**KIRKLEES METROPOLITAN COUNCIL
INVESTMENT & REGENERATION SERVICE**

DELEGATED DECISION TO DETERMINE PLANNING APPLICATIONS

Reference No:	2024/62/93028/E
Site Address:	Smithies Moor Rise, Birstall, Batley, WF17 8AX
Description:	Roof alterations to existing storage unit, erection of infill extension and boundary treatment
Recommending Officer:	Elenya Jackson

Officer Report

Drawing Number **24-003 - PL - 04**

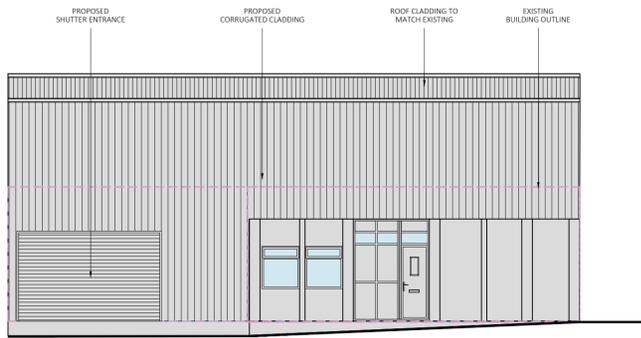
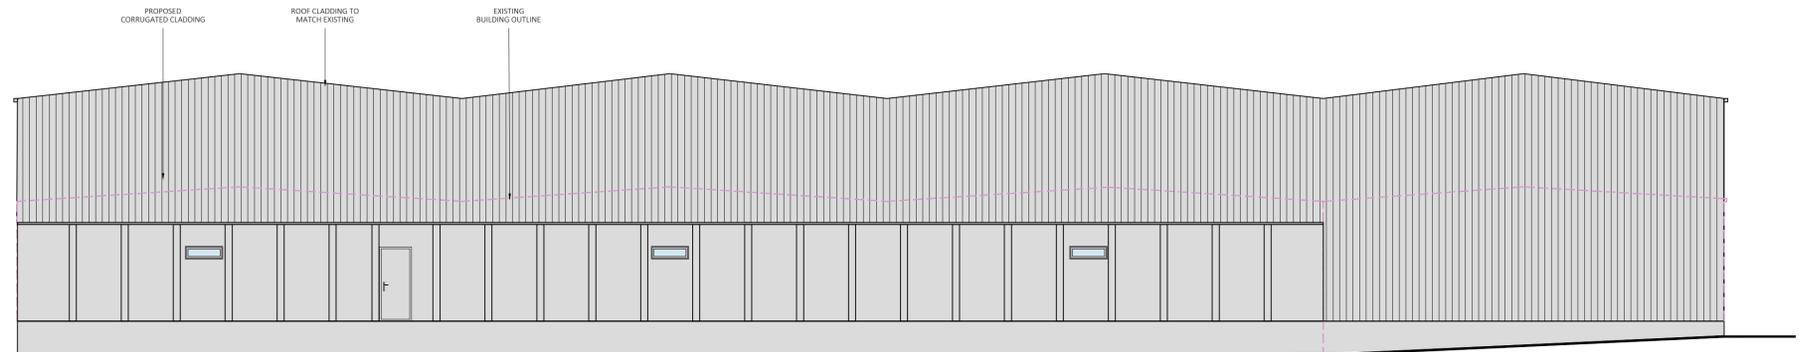
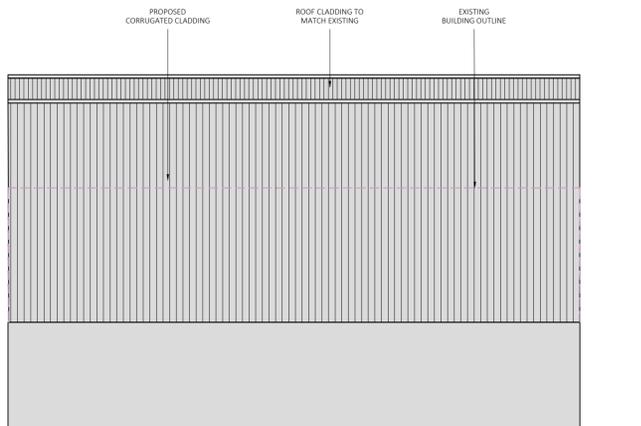
The proposed infill extension would have a length of 11.3m with a width of 6.5m and a maximum height of approx. 7.9m

The external walls of the building would be constructed from corrugated metal panels; however, the colour of this has not been specified. It is considered that the details of materials could be secured via condition.

It is considered that, although the structure would have a large scale, it would be of a simple form and would be subservient in relation to the existing buildings.

3. Prior to commencement of the alterations to the superstructure of the building hereby approved details of all materials and their colour finish to be used in the construction of the development hereby approved shall be submitted to, and approved in writing by, the Local Planning Authority. The development shall be undertaken in accordance with the approved scheme which shall thereafter be retained for the lifetime of the development.

PROPOSED OTHER SIDE ELEVATION
Scale 1:100@A1

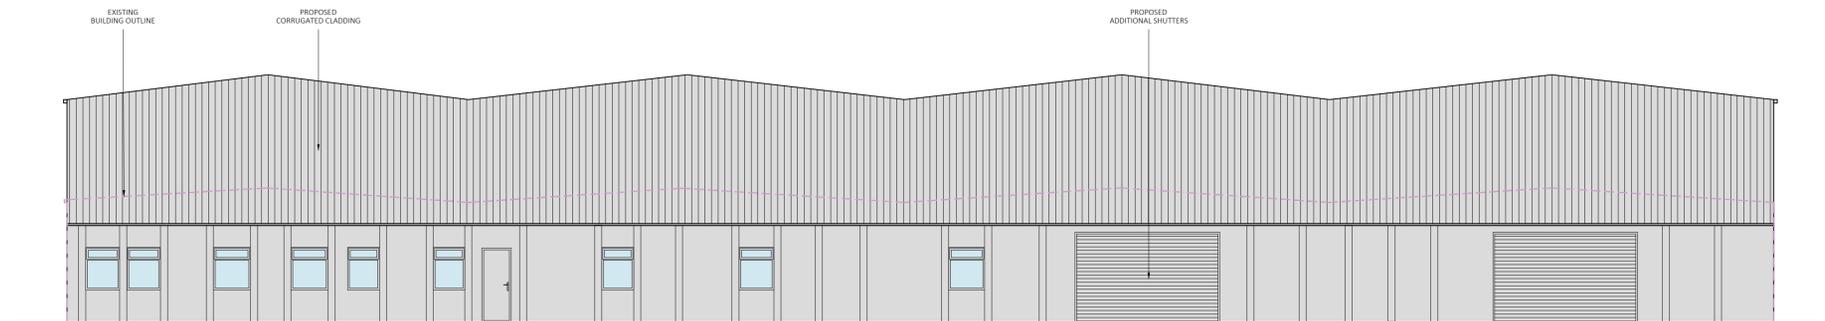
There are side facing doors to the unit on the southern elevation. There potential this could create a disturbance to neighbours if not suitably mitigated and it is therefore considered reasonable to condition these to remain closed between the hours 18:00 and 09:00 Monday to Saturday with no opening on Sundays and bank holidays. This is consistent with the opening hours of neighbouring business' opening hours.

12. The side facing vehicular access doors upon the drawing titled 'Proposed Other Side Elevation' upon drawing PL04 shall only be operational between 09:00 and 18:00 Monday to Saturday and shall remain shut at all other times including on Sundays and bank holidays.
